Rezoning Transportation Analysis
Petition Number: Insert Zoning Petition #2021-207
General Location Identifier: 15902801

Revision Log:

Date	Description
01/21/2022	First Review (WB)
02/21/2022	Second Review (WB)

SITE PLAN

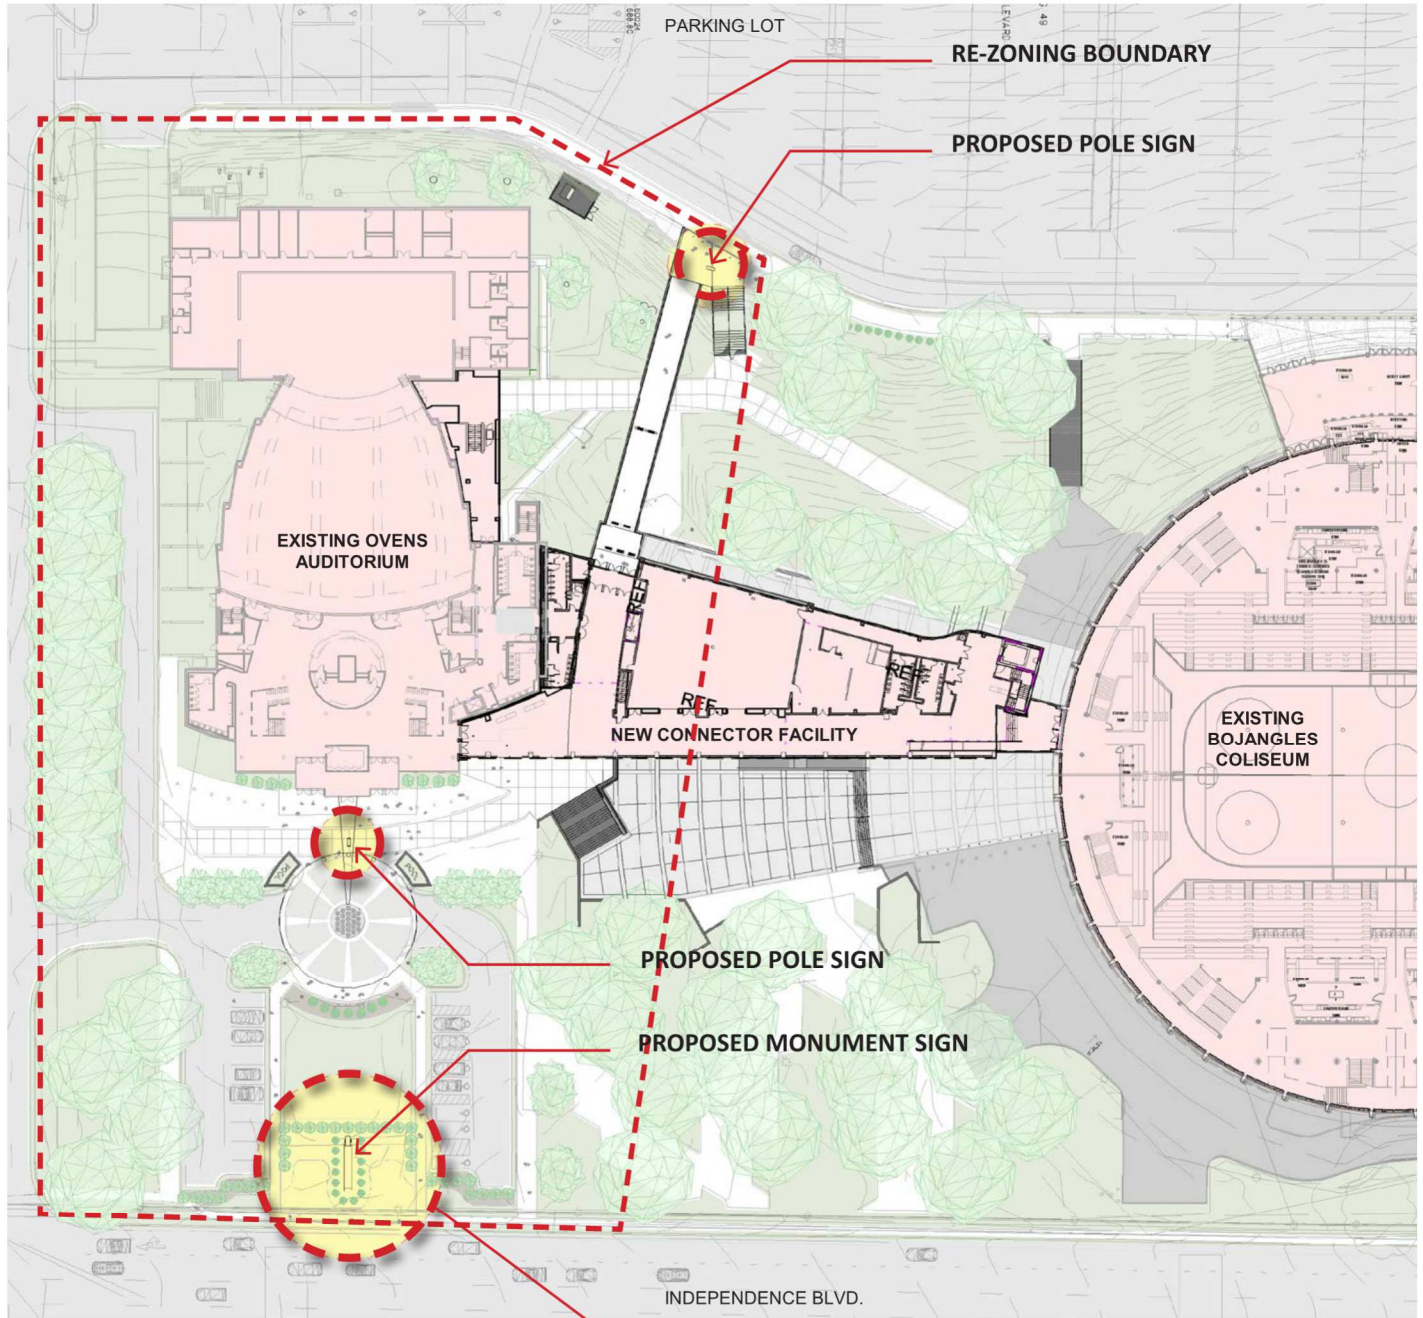
1. **Curblines:** The proposed zoning district has a setback measured from back of the existing or proposed future curblines.
 - a. **Independence Blvd:** The future location of curb and gutter is in its existing location.
 - b. **Coliseum Drive:** The future location of curb and gutter is in its existing location.

Label and dimension the curb and gutter from the centerline for each road on the site plan.
